RFI

RFI #: 123
Date: 5/21/2012
Job: EB-02 Keller Springs Lofts
Phone: 877-777-5115

Subject: A2 & A2-SP Cased Openings

Drawing: A2.3 & A2.3A
Cost Impact: None

**A2-SP ONE BEDROOM/ONE BATH**  
SCALE 1/4"=1'-0"

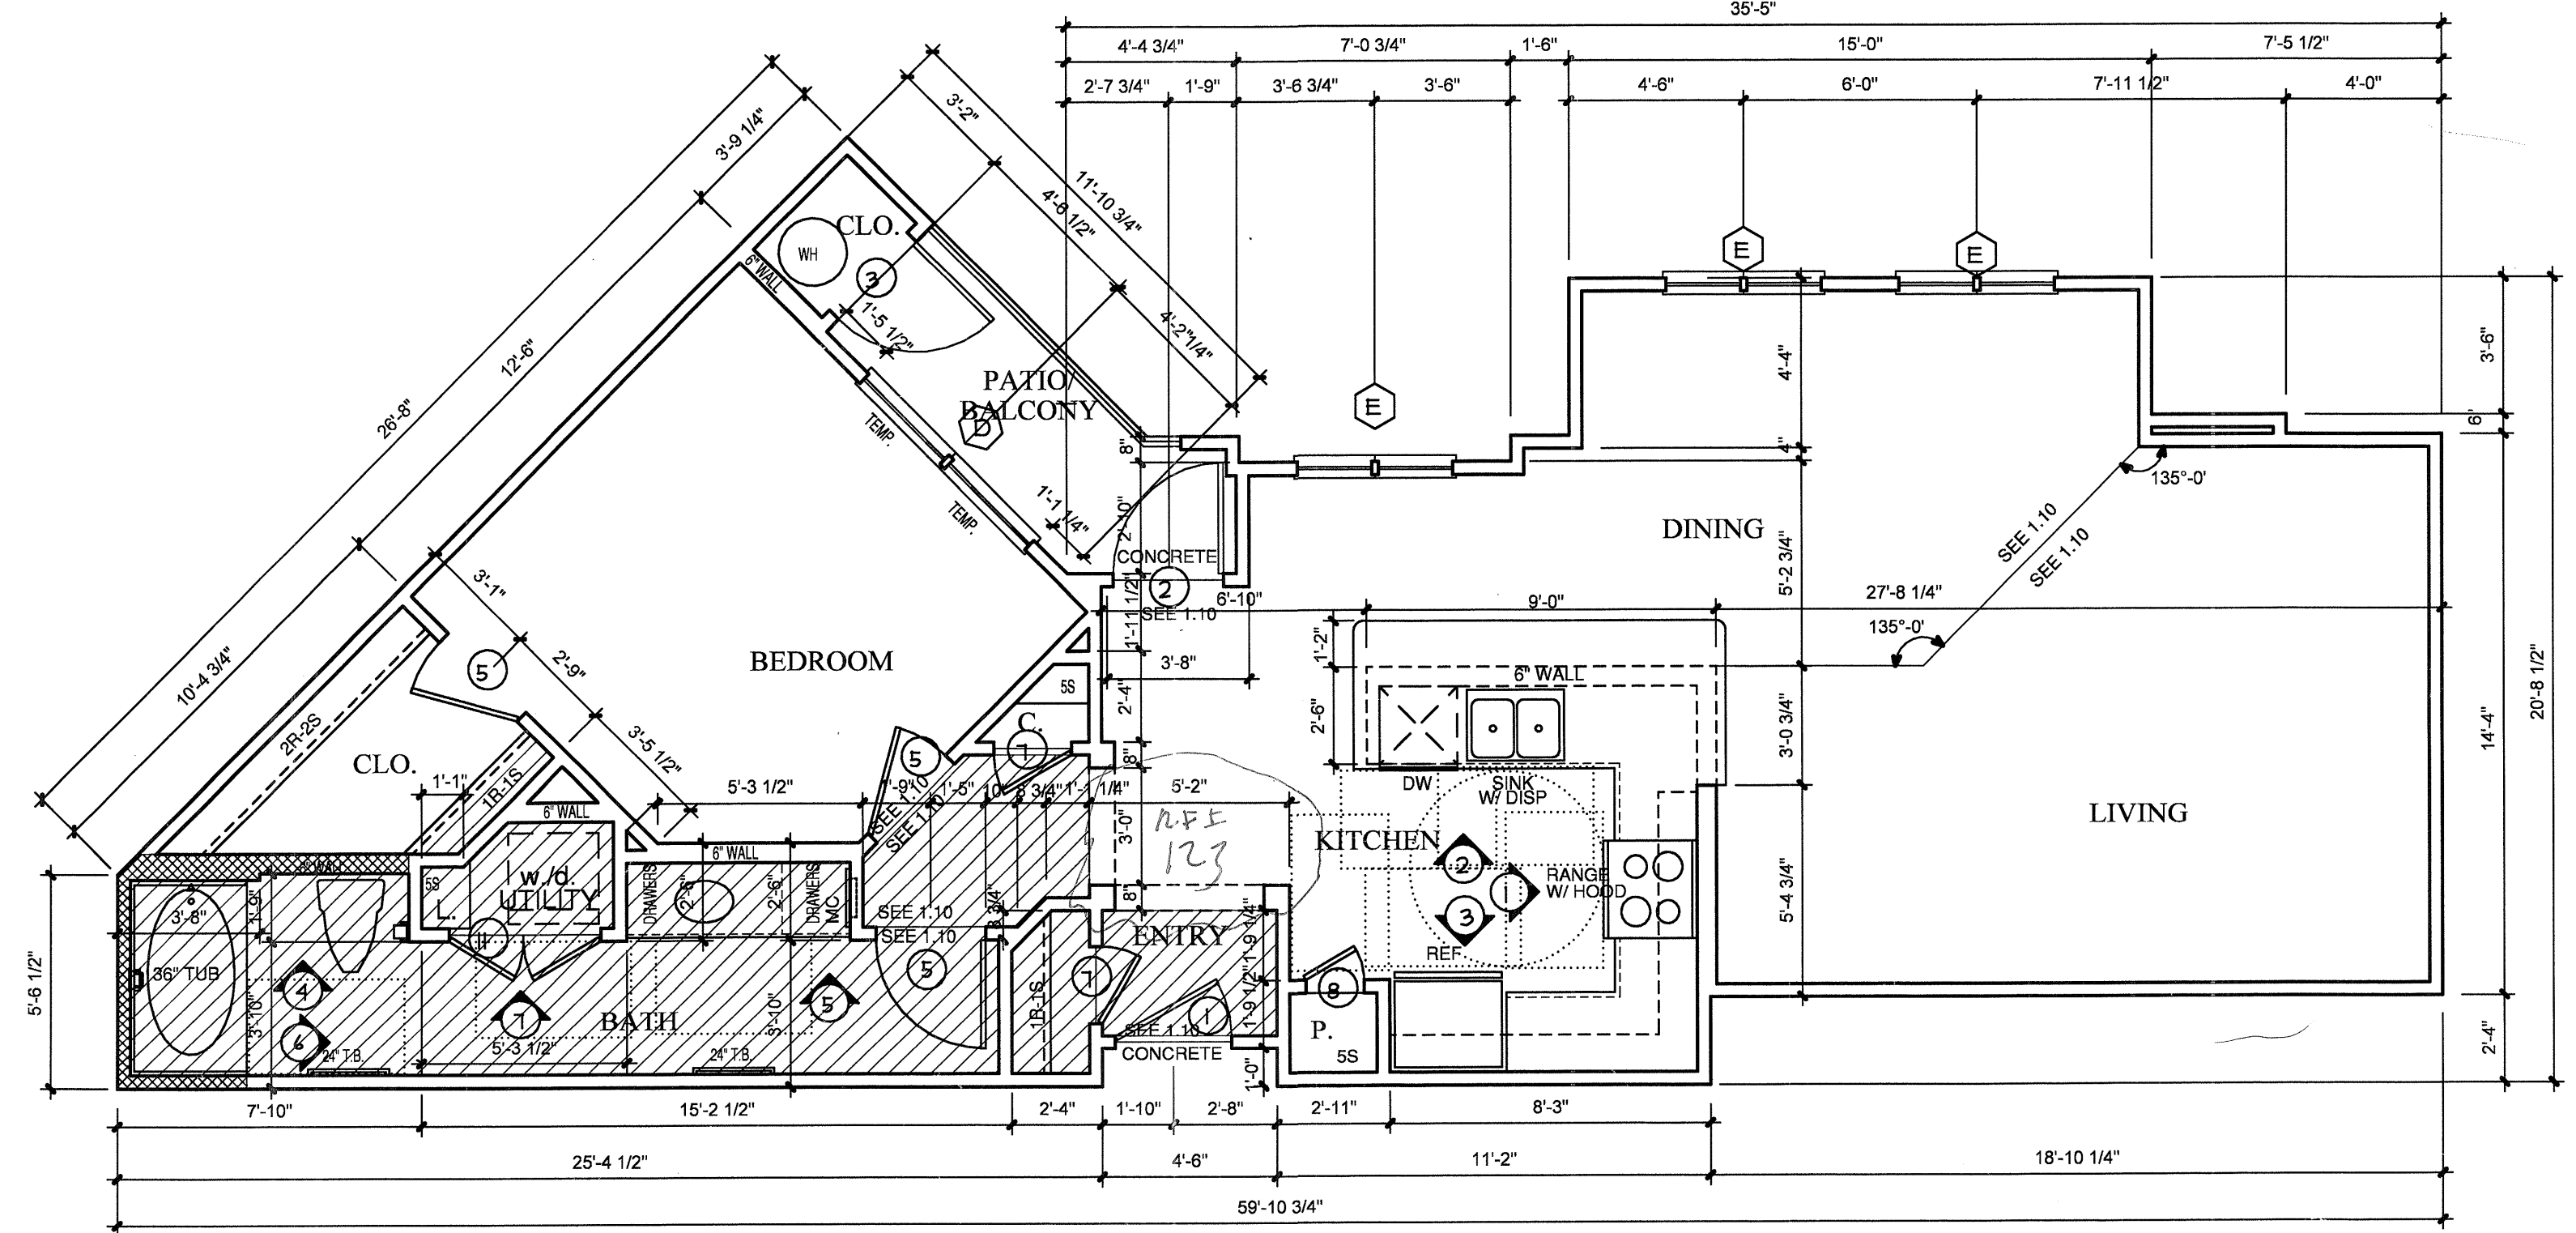
Request: Date Required: 5/29/2012
A2 Unit - A cased opening is called for between the LR and the hallway. Is this a wood cased opening? Please provide an elevation sketch to show height.
A2-SP Unit - Dashed lines are shown between entry and kitchen and between the kitchen and hallway. Are these cased openings? If so, please provide an elevation sketch showing opening heights.

Response: In both units, the cased opening is a flat opening at 6'-8" just like a door opening. Adding the wood casing is your option. BGO is fine with or without a door frame trim going around the opening.
